**Addendum No. 1**

RE: Contract ID C203658

**Johnston County (I-3318BB)**

Bridges #114 and #116 Over Little River On I-95

USE FOR LIGHTING CONSTRUCTION ONLY

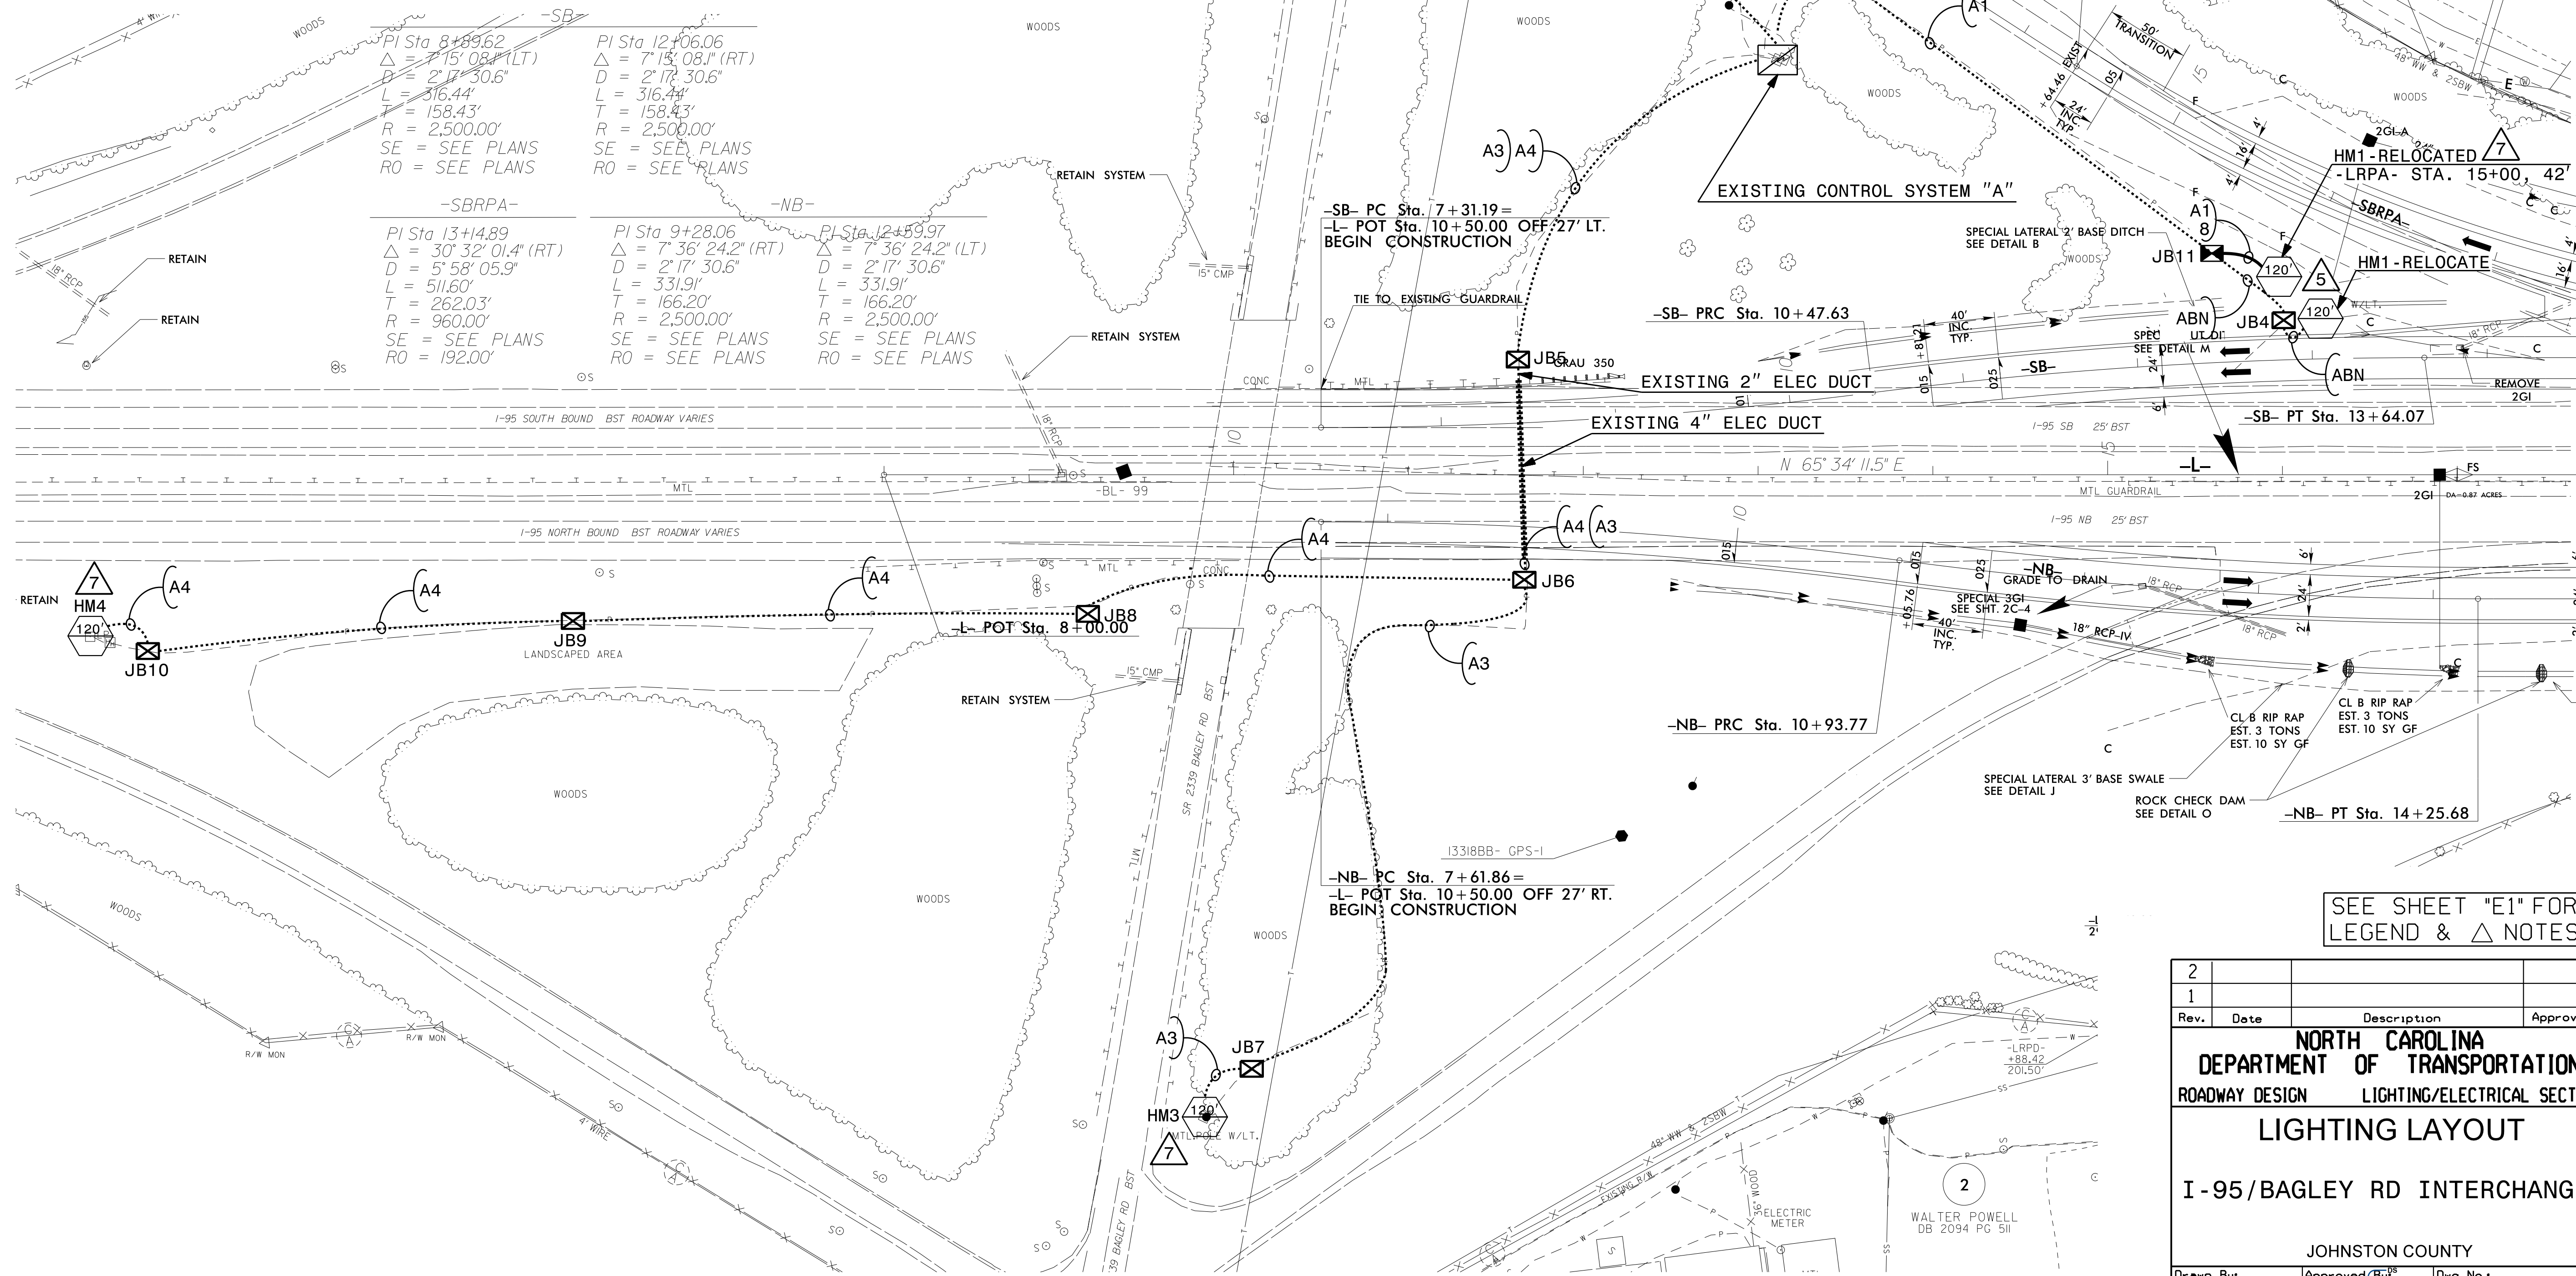
Sheet No.	Revisions
1A	Revised "Index of Sheets" to show the addition of Sheet Nos. E-1 thru E-3 Electrical Plans to the plan set. Please void Sheet No. 1A in your plans and staple the revised Sheet No. 1A thereto.
E-1 thru E-3	Electrical Plans added for some adjustments to existing high mast lights at the Bagley Road/ I-95 interchange. Please staple New Sheet Nos. E-1 thru E-3 after existing Sheet No. PMP-3 in your plans.
